Subject: RE: Planning Consultation on: BR/114/20/PL

Site Address: 13-17 Abbeyfield Richmond Avenue Bognor Regis PO21 2YE

Description of Works: Conversion of existing vacant residential care home into 10no. flats

DRAWING
PROPOSED PLANS
DRAWING No
313/03
SCALE 1:100
DATE APRIL 20
DRAWN LA
CHECKED

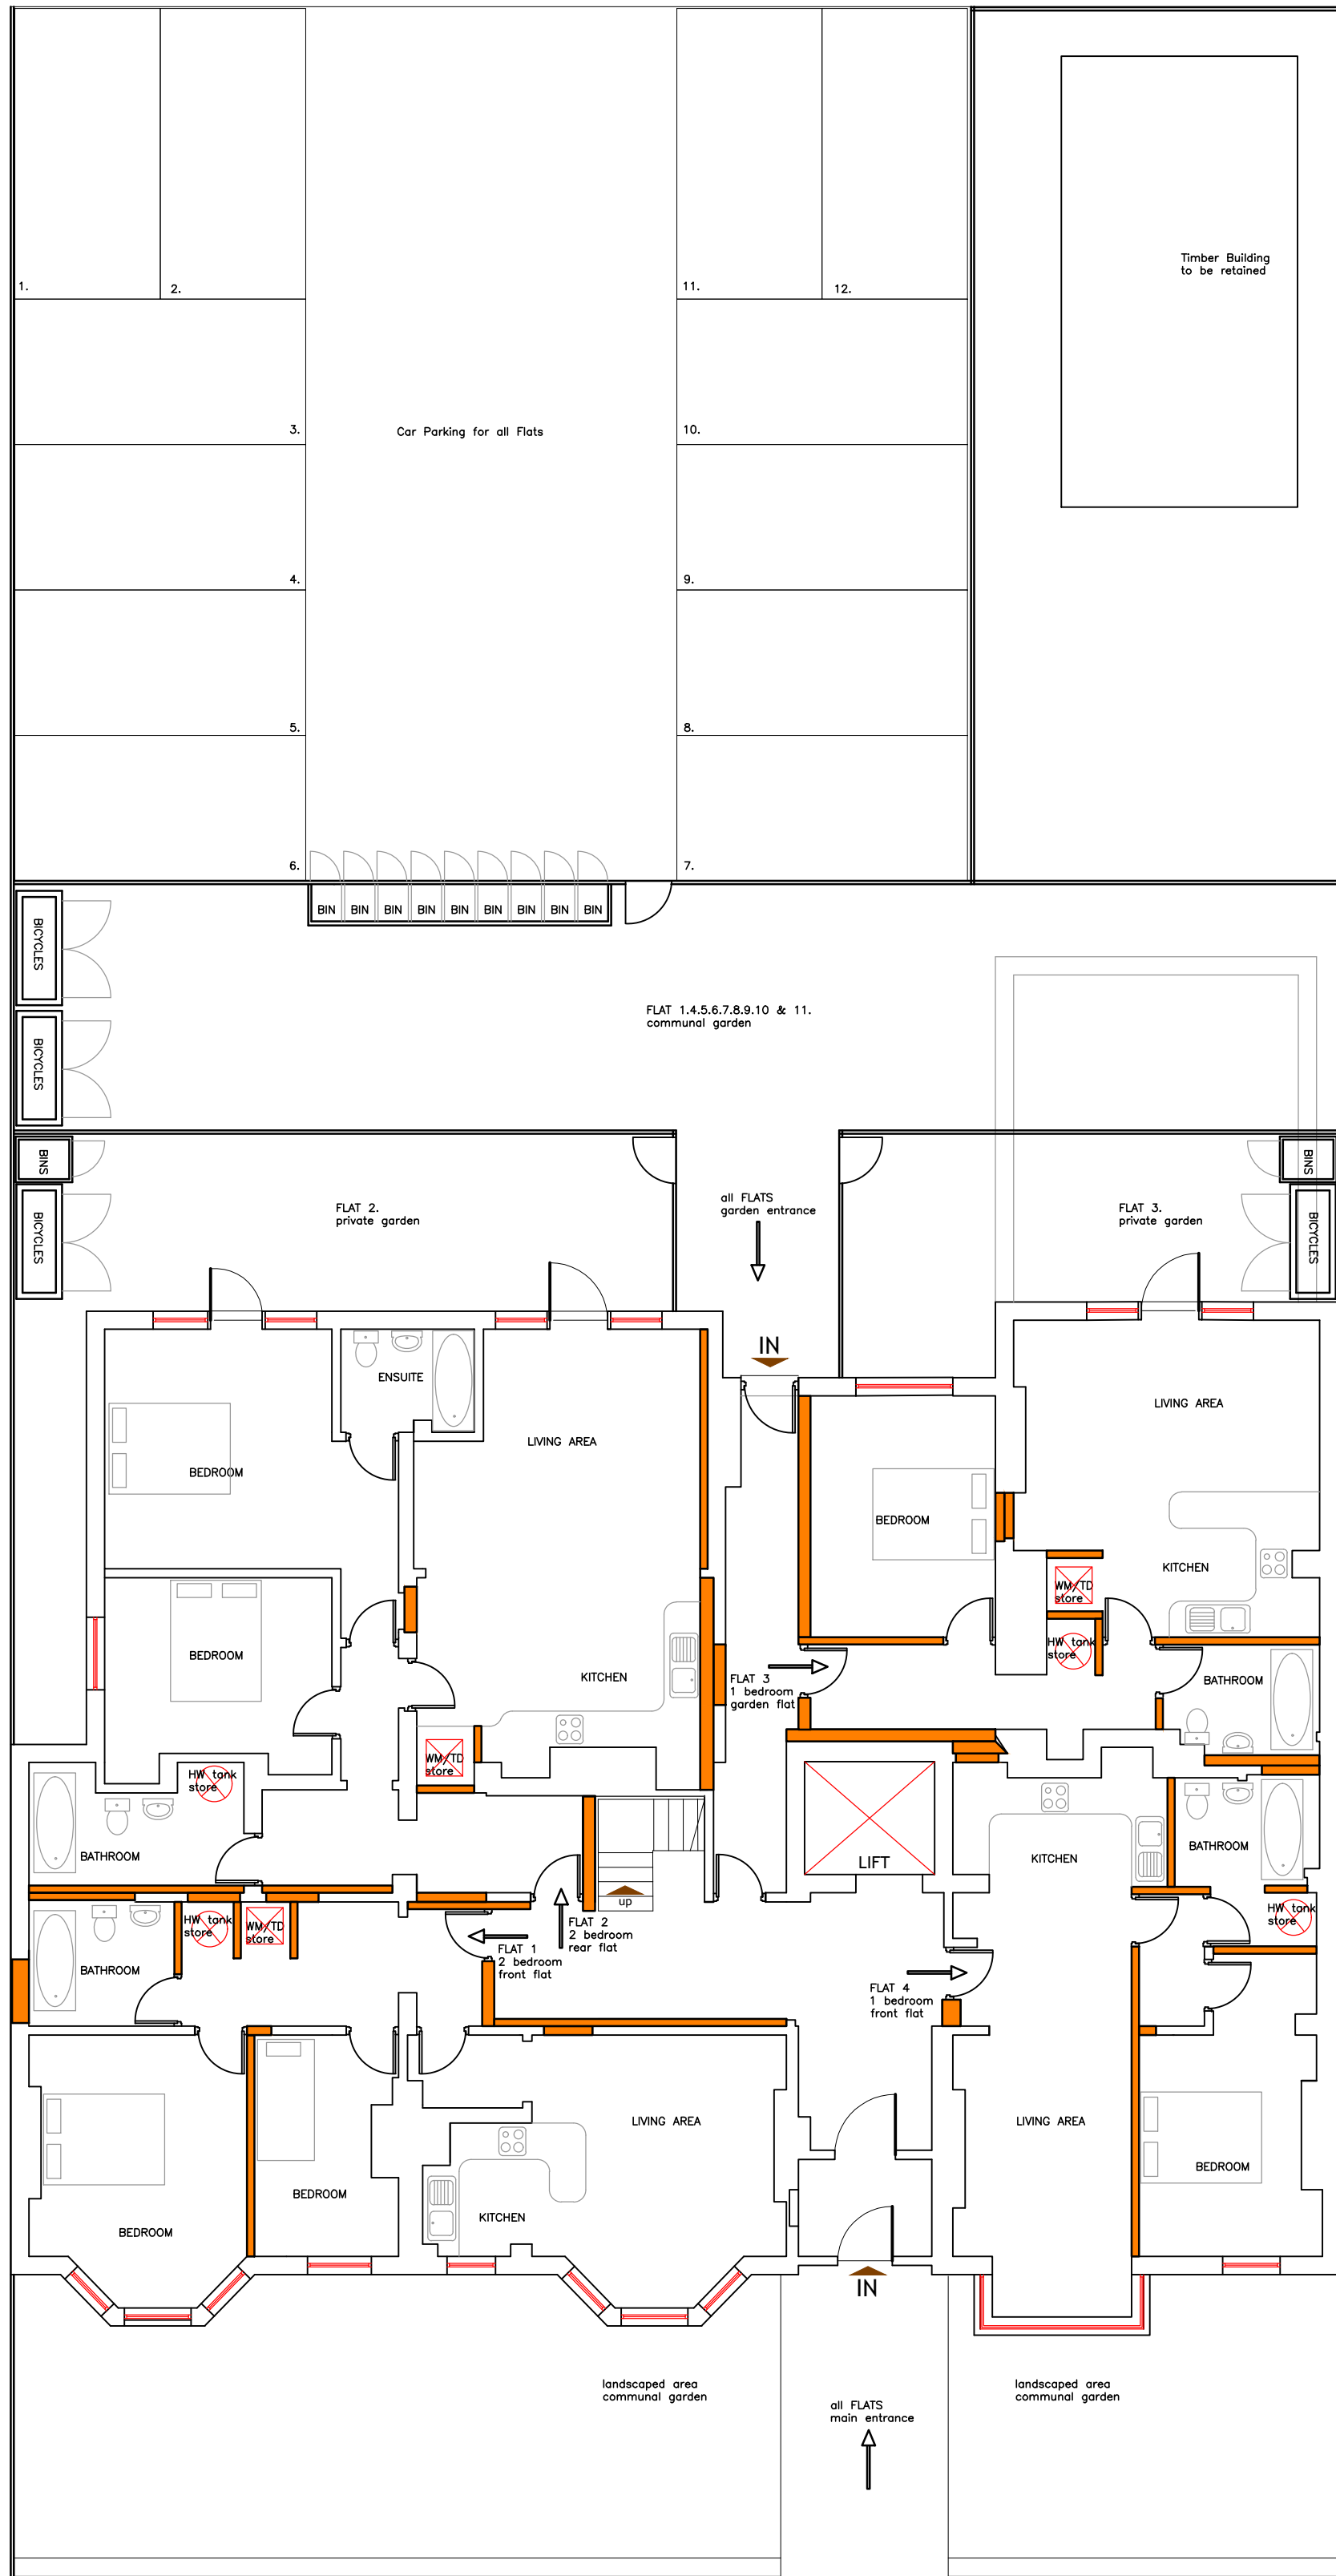
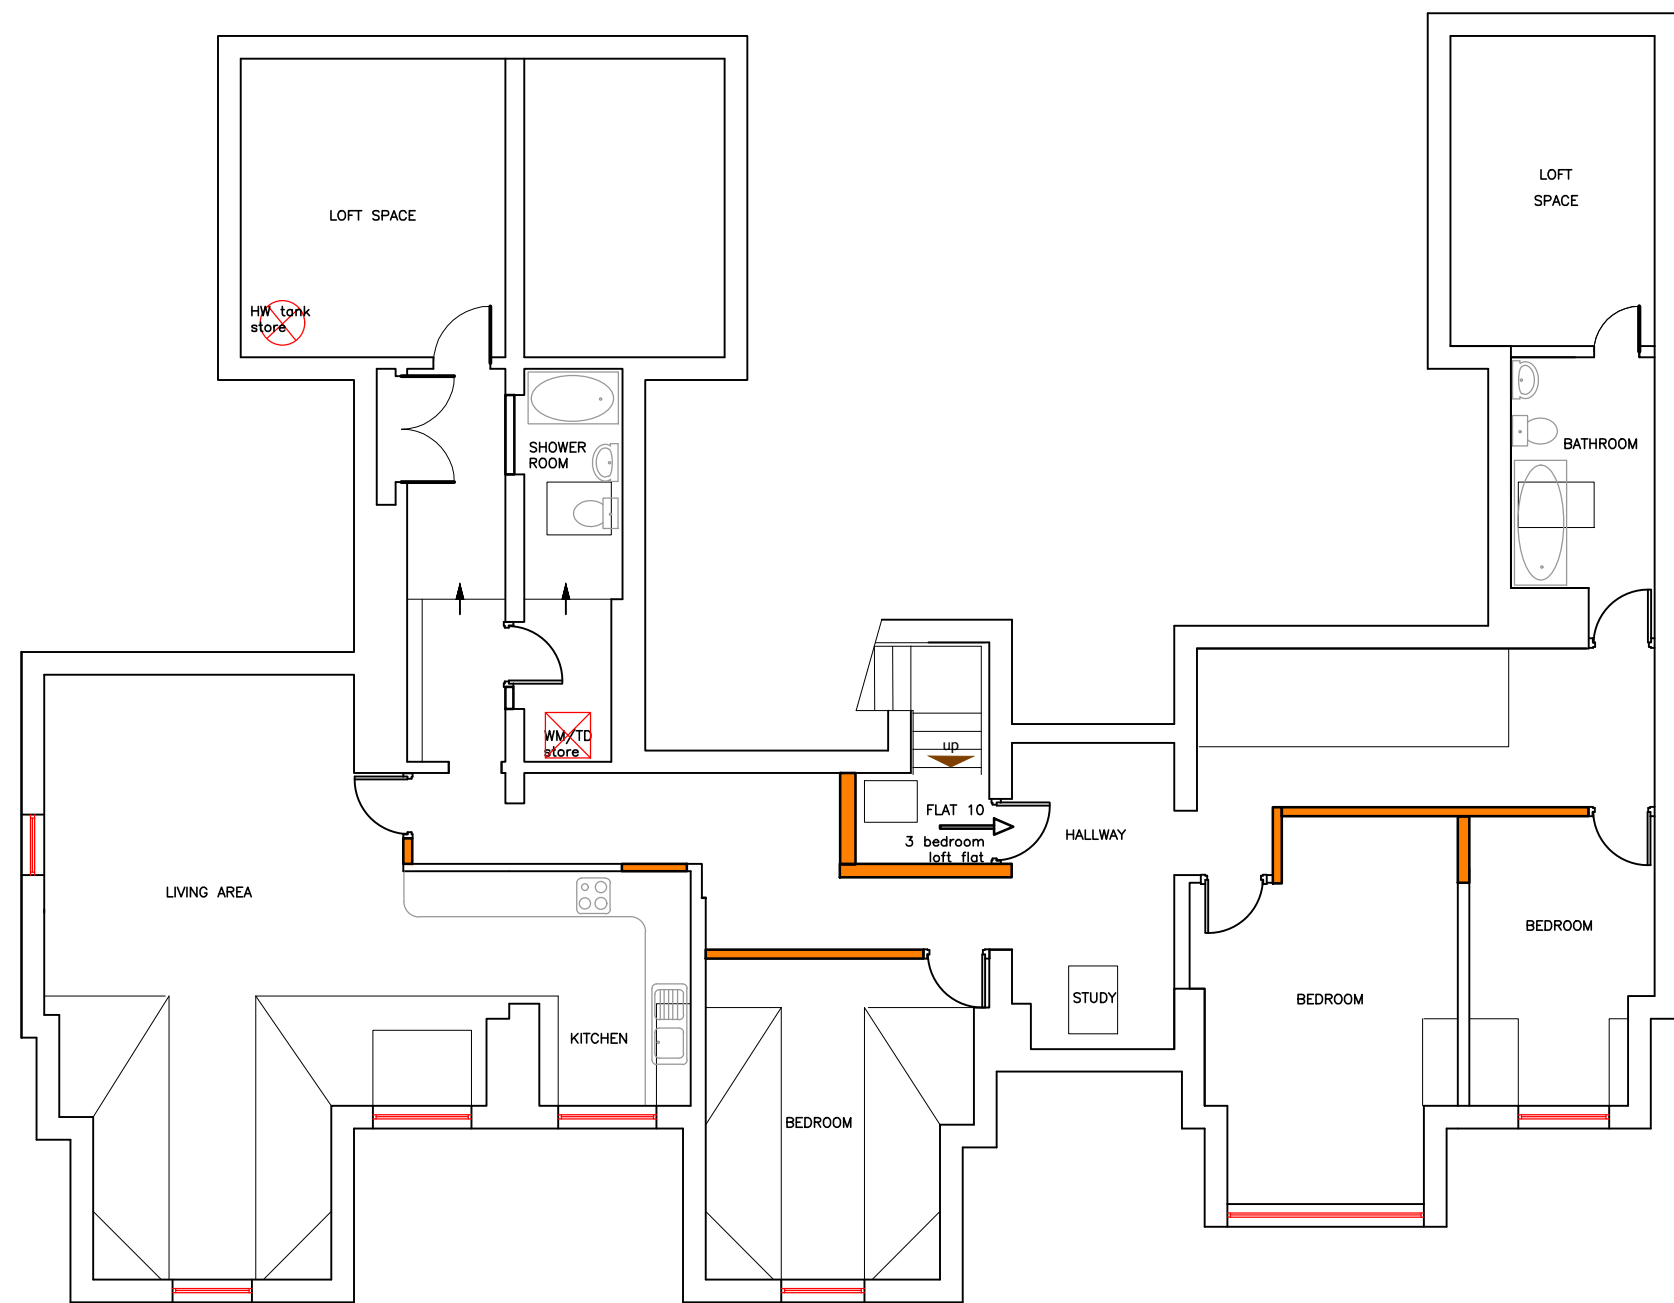
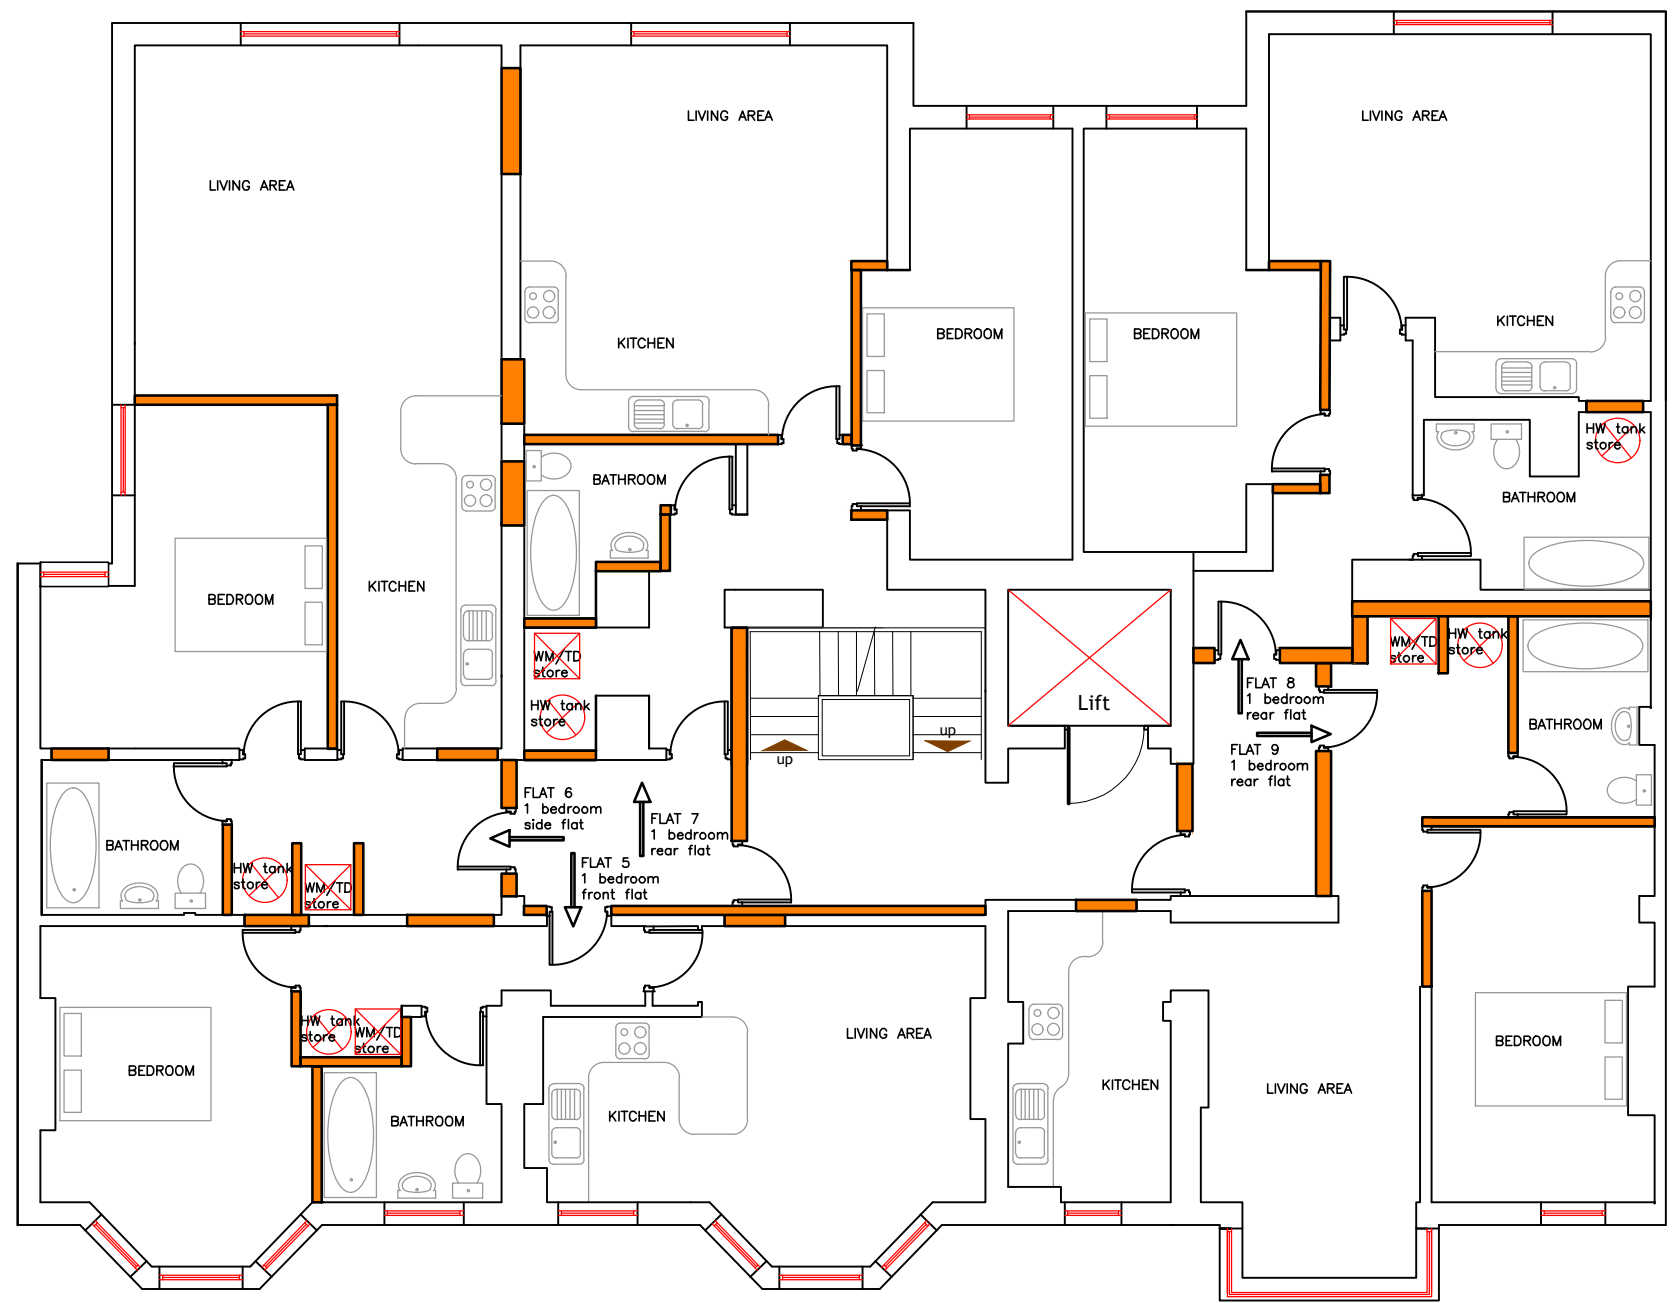
- Appropriate fire precaution facilities and equipment must be provided of such type, number and location as are considered necessary. Guidance on fire safety is contained in the LACORS guidance document – “Housing – Fire Safety, Guidance on fire safety precautions for certain types of existing housing”
- 30min fire resisting escape route, including 30 minute fire resisting and self-closing fire doors to each flat entrance and within the communal areas
- A mixed Grade A, LD2 and Grade D1, LD3 fire system should be maintained and installed.
Grade A, LD2 system:
 - Interlinked detection throughout the escape route
 - Interlinked heat detection to each flatGrade D1, LD3 system:
 - Non-interlinked mains-wired smoke alarms with integral tamper-proof battery back-up to each flat
- Emergency lighting throughout the escape route may be required as there is no effective borrowed light

- Consideration should be given to re-locating the washing machine/tumble dryer stores within the flats. These items are a high fire risk and a number of them are situated within the escape route of the individual flat. If this item were to catch fire, the flat occupant(s) would have to pass the store in order to evacuate the property. An alternative to re-locating the washing machine/tumble dryer stores is to have a sound, close-fitting door fitted, as opposed to the current 'open' layout

- Note with regards to bedroom sizes:
6.5m² – suitable for 1 person
10m² - suitable for 2 persons
- Note with regards to children and how they fit into bedroom size calculations:
Babies up to the age of 1 are discounted
Children aged 1 up to 10 years are classed as half a person
Children aged 10 years+ are classed as a person
- The floor to ceiling height must be at least 2.1 metres from floor to ceiling over at least 50% of the floor area when measured at a height of 1.5metres from the floor and provide sufficient useable space
